The concerns raised by Thurlaston Parish Council in our Representation made on 10th May 2023 have not been addressed by the Applicant in any of the process to date. Our concerns in relation to this application have only been heightened.

Thurlaston Parish Council

### ES FIGURE 14.4 - MAIN HNRFI SITE CONCEPT SURFACE WATER DRAINAGE STRATEGY

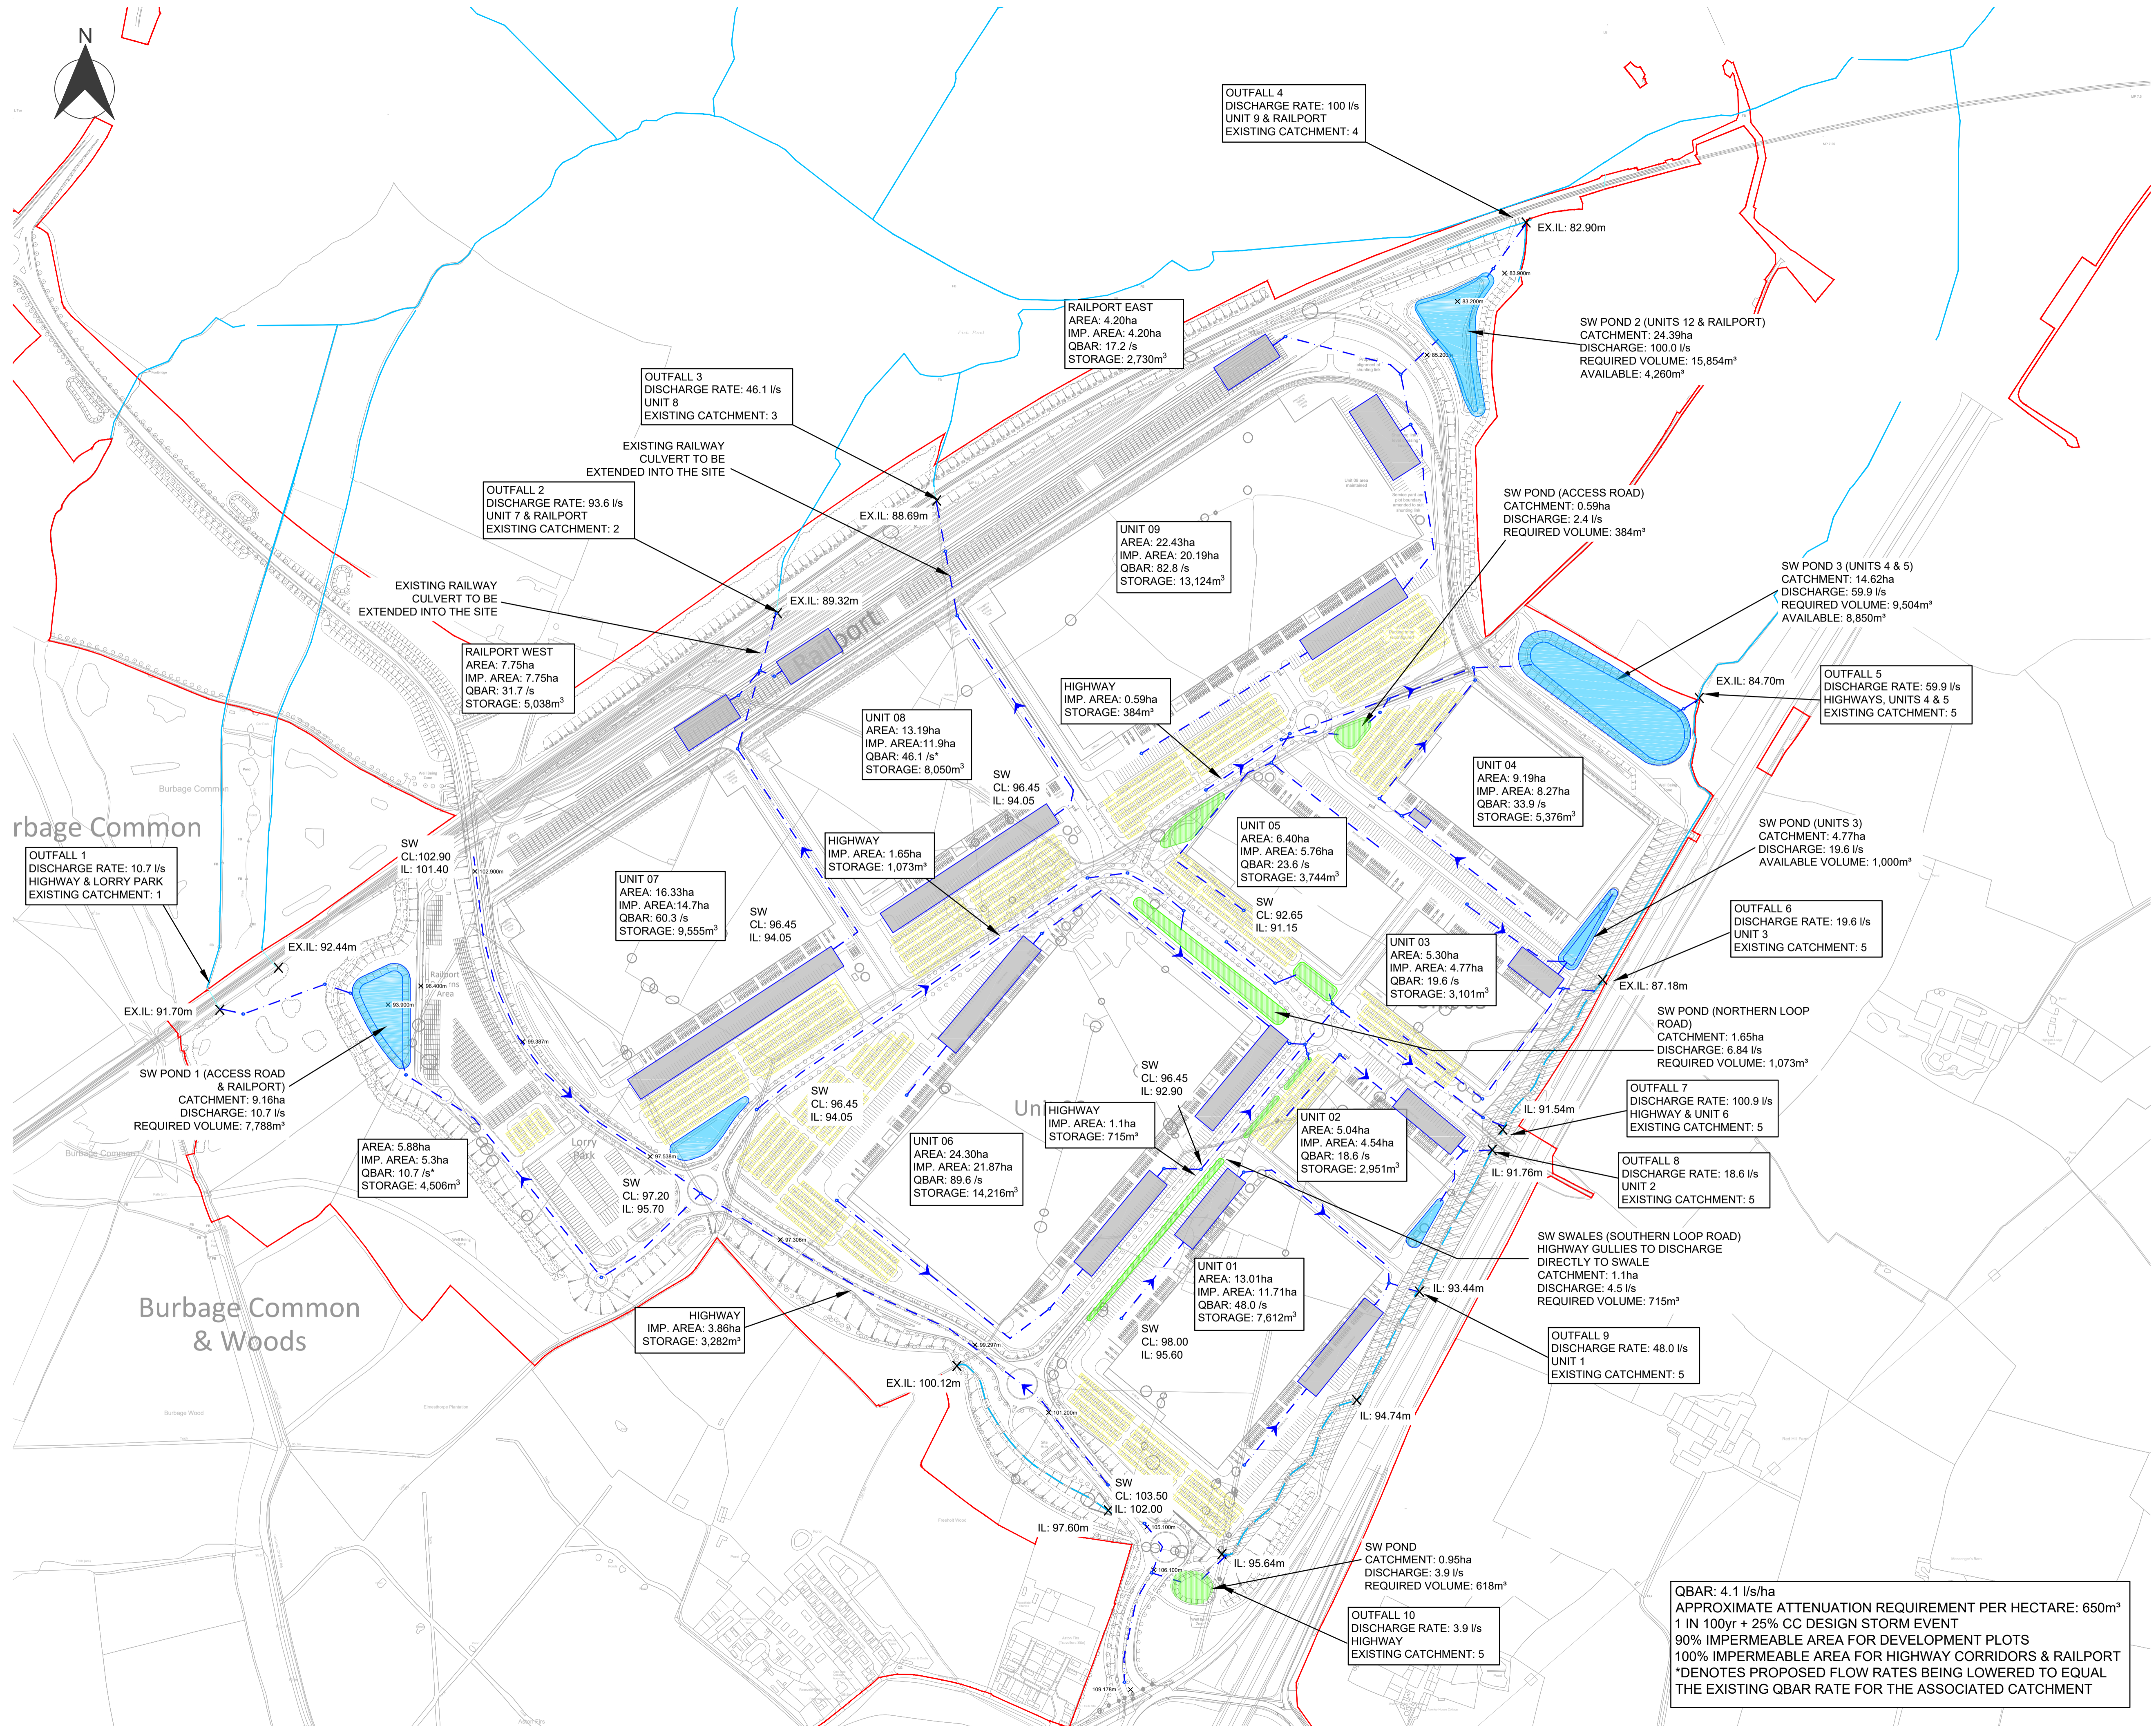
Since our first representation was made it has come to our attention that part of the water catchment area of Thurlaston Brook is included within the planned site of the development. It is not apparent from the Developer's application what steps are to be taken to investigate any impacts upon downstream areas.
